113 Newbury St.

Bay House

HAMPSHIRE STREET PROPERTIES

Hampshire Street Properties
Neighborhood Meeting Minutes

B
FRANKLIN STREET ELEVATION
SCALE: 1/16"=1'-0"

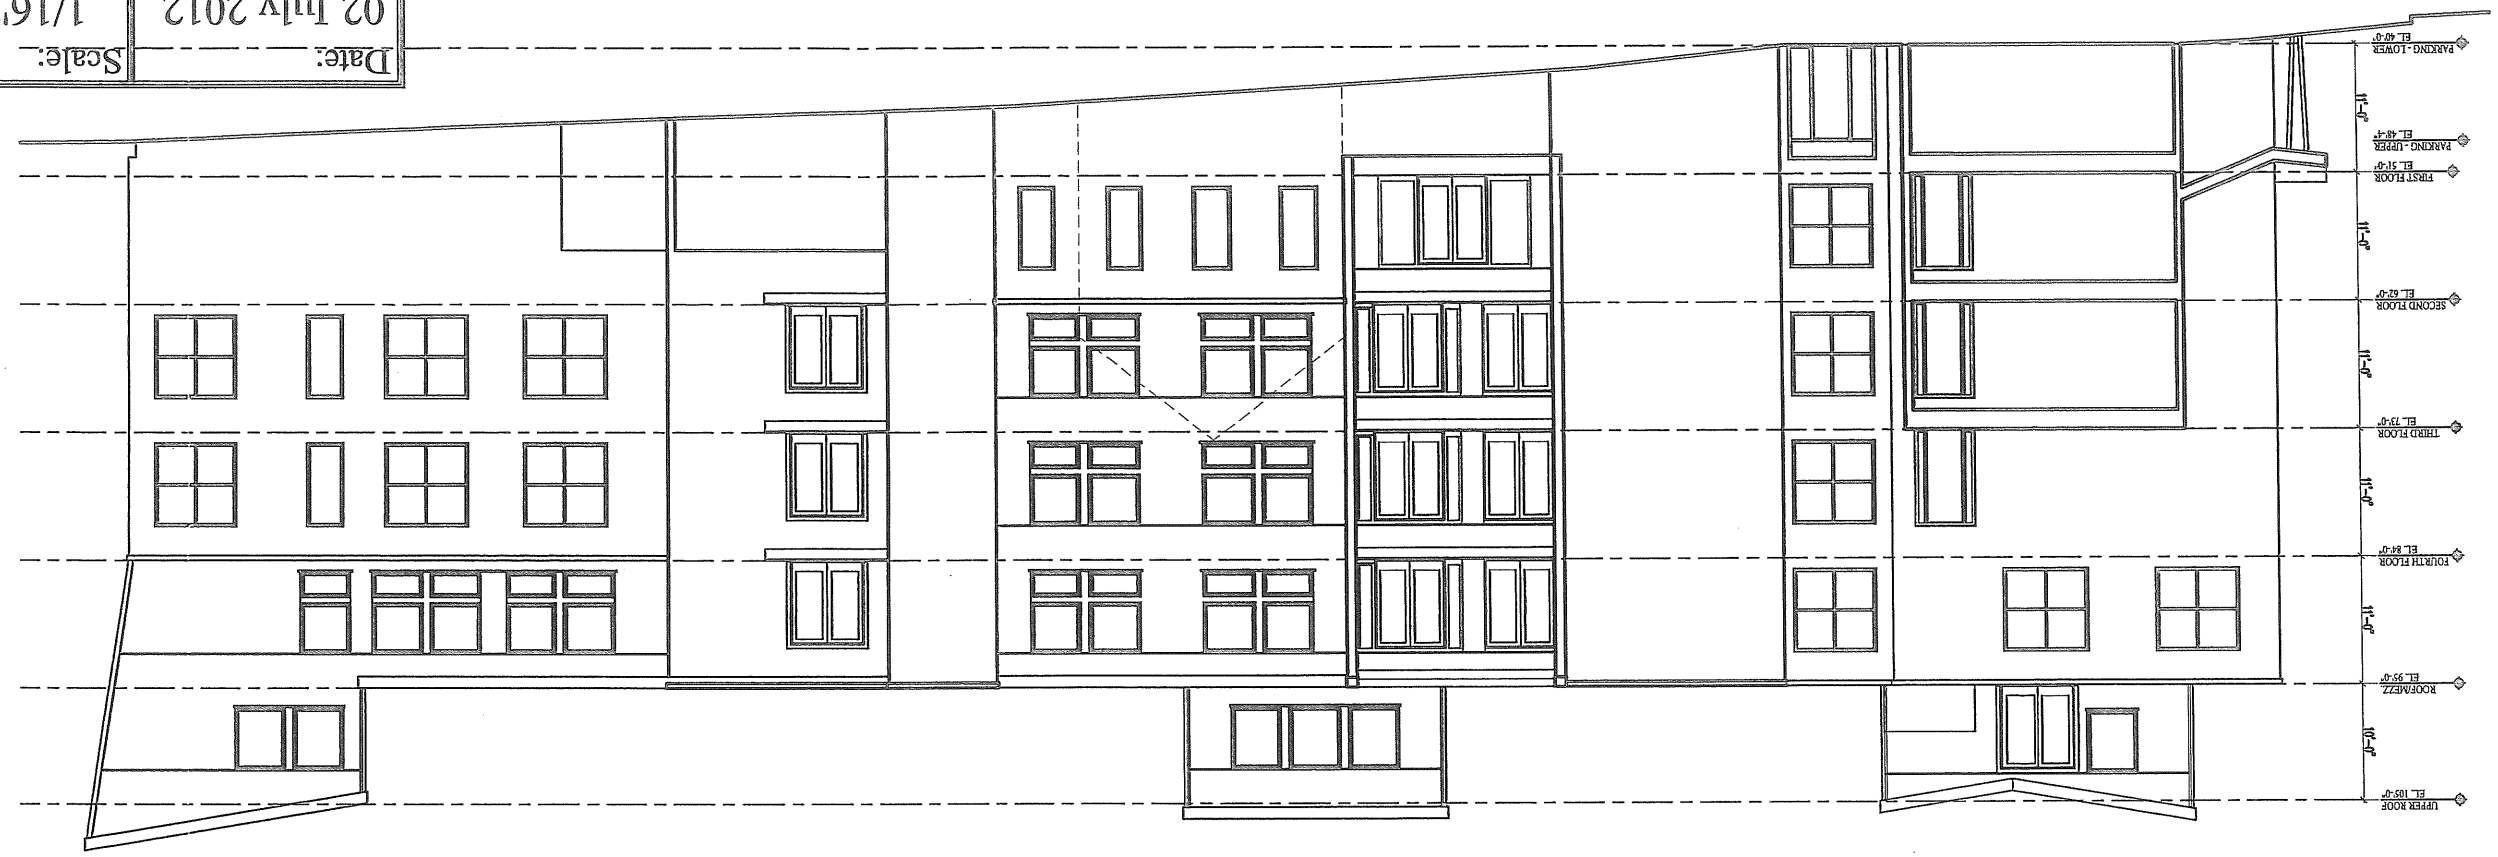
Q: "Something" will happen. The building will need to engage Franklin. Many buildings have turned their back on Franklin. This building should not turn its back on Franklin. It is a pretty façade but it is the back of a building.

However, allowing this project to do otherwise would be a great risk to the integrity of the vision for an urbanized Franklin Street and for the applicant's property. When Franklin St. is reclaimed, this building will stick out as one that turned it's back on the street when it could have done otherwise. Furthermore, if the developer were to choose not to face Franklin, and the future realignment of the roadway results in excess space being created between this building and the roadway, a future building could side right up to this building with a zero set-back. The result would be a shame for future residents of this building and the view corridor that this building attempts to maximize.

- The development must actively engage Franklin Street. Preliminary plans showing a 1st floor parking deck along the entire length of Franklin Street contradict active engagement, and must be re-considered.
- The connection of Federal and Newbury Streets to Franklin Street should be considered, and if these connections will not be made as a part of this development, funding should be provided by the developer to reserve as contribution to the future construction of these connections.
- The corner locations facing Franklin Street (at Federal and Newbury) must be designed in a manner that supports the re-connection of these streets to the urban grid. These important corners should create minor gateways from Downtown into the India Street neighborhood. These corners should have strong architecture, functioning entrances, active street-side uses, and a robust pedestrian realm.

I just stopped by City Hall to have a look at the preliminary drawings for the Hampshire Street project, and they stink. Not only is there a blank parking garage wall on Franklin Street, but also on Newbury and Federal. There are no active street-level uses whatsoever - no windows and no doors except the gaping maw of the garage.

A: (David Lloyd) Completely disagrees. This will be the most dynamic façade on the entire Peninsula and will celebrate Franklin. The building faces Franklin not turns its back on it.
